Application for a non-material amendment following a grant of planning permission.
 Town and Country Planning Act 1990

ERECTION OF 6 DETACHED RESIDENTIAL DWELLINGS

PA20/08658

MINOR CHANGES TO BLOCK PLAN/LAYOUT
MINOR CHANGES TO PLOT 6

STATUS PRELIMINARY	DRAWING No. 2812.2.7
------------------------------	--------------------------------

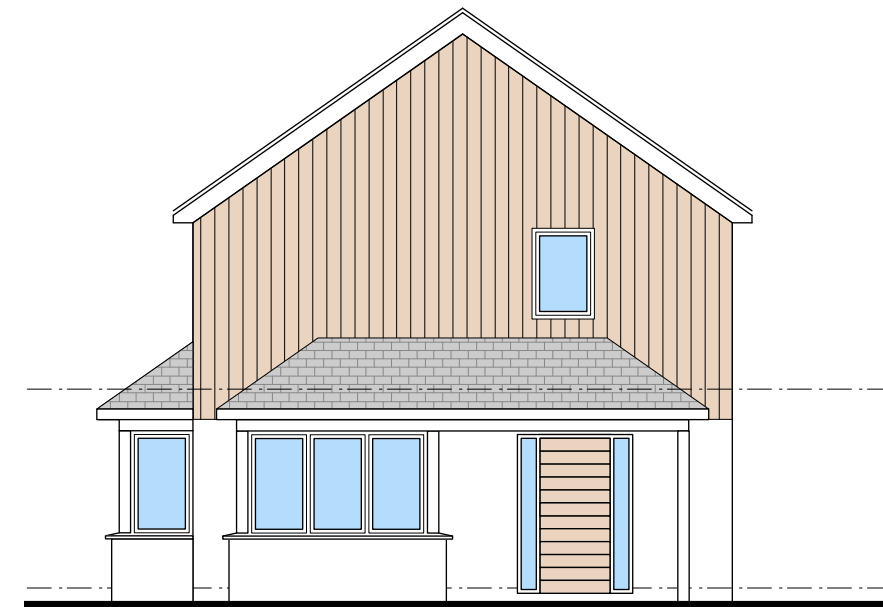
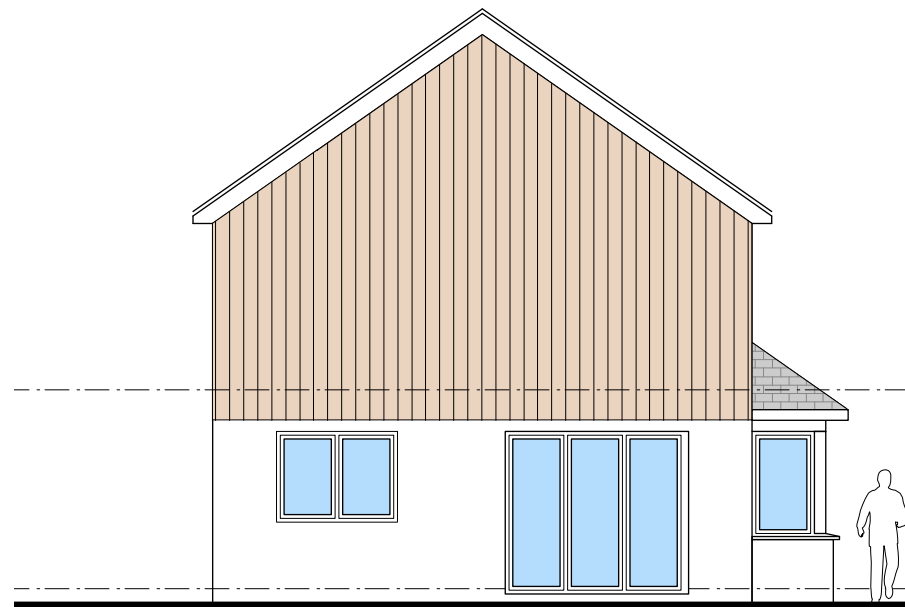
SOME OF THE DWELLINGS AS APPROVED WERE INTRUDING, ALBEIT MINOR, INTO THE SWW SEWER PROTECTION ZONE! WHEN THE EXACT POSITION OF THE SEWER WAS ESTABLISHED AND WAS IN A DIFFERENT POSITION TO AS SHOWN ORIGINALLY

2812.3.220 C / 2812.2.7 A / 2812.3.210 C
